# CITY OF ALBUQUERQUE

August 13, 2015

**Re: Advanced Auto Parts  
San Mateo & Claremont  
Traffic Circulation Layout**  
Engineer's/Architect's Stamp dated 8-7-15 (H17-D111)

Based upon the information provided in your submittal received 8-12-15, the above referenced plan cannot be approved for Building Permit until the following comments are addressed:

PROJECT NO.:	CAD008.01
DESIGNED BY:	JDC
DRAWN BY:	JDC
DATE:	08/07/2015
C1.2	
SHEET 1 OF 2

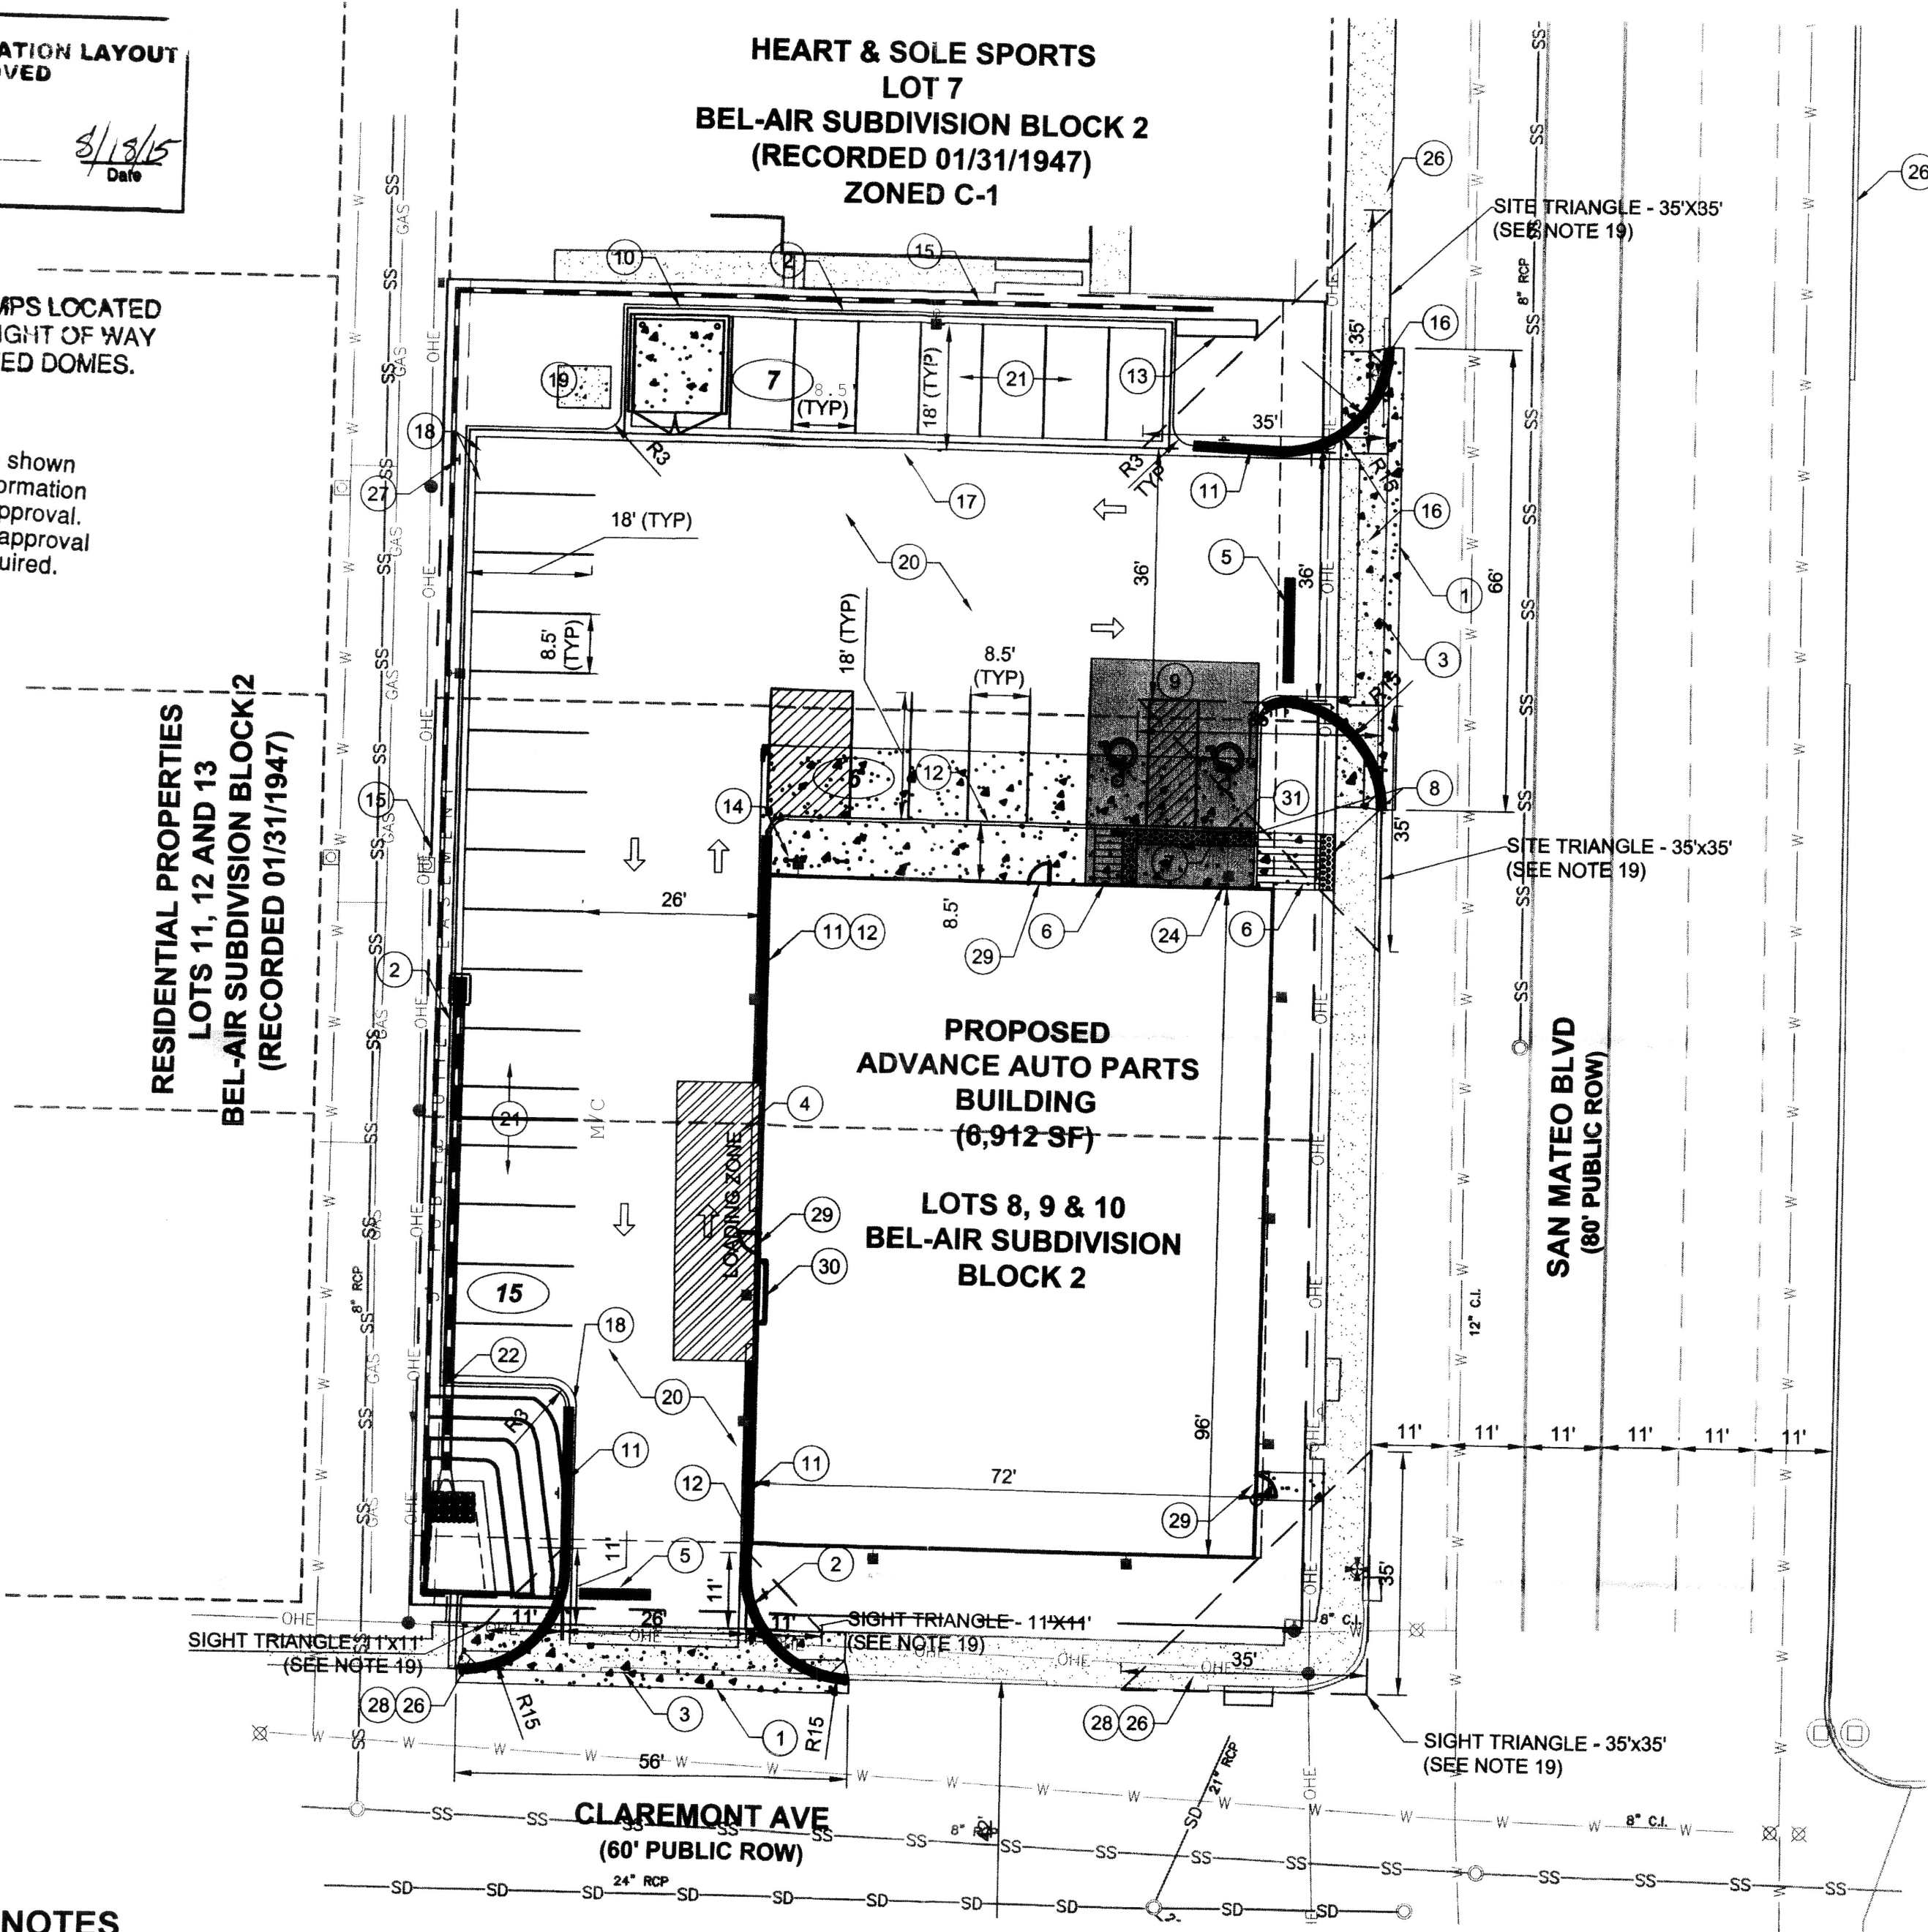
1. The handicap accessible spaces must be a minimum of 8.5 feet in width and 20 ft. in length. Per the submitted drawing, the proposed handicap parking space are 18 ft. long with a bumper car stop, which will yield at most a total length of 16 ft. length with a 2 ft. overhang. Please adjust the handicap parking space for a total of 20 ft. in length, while still retaining a minimal 6 ft. ADA pedestrian walk way.
2. Please include two copies of the traffic circulation layout at the next submittal.
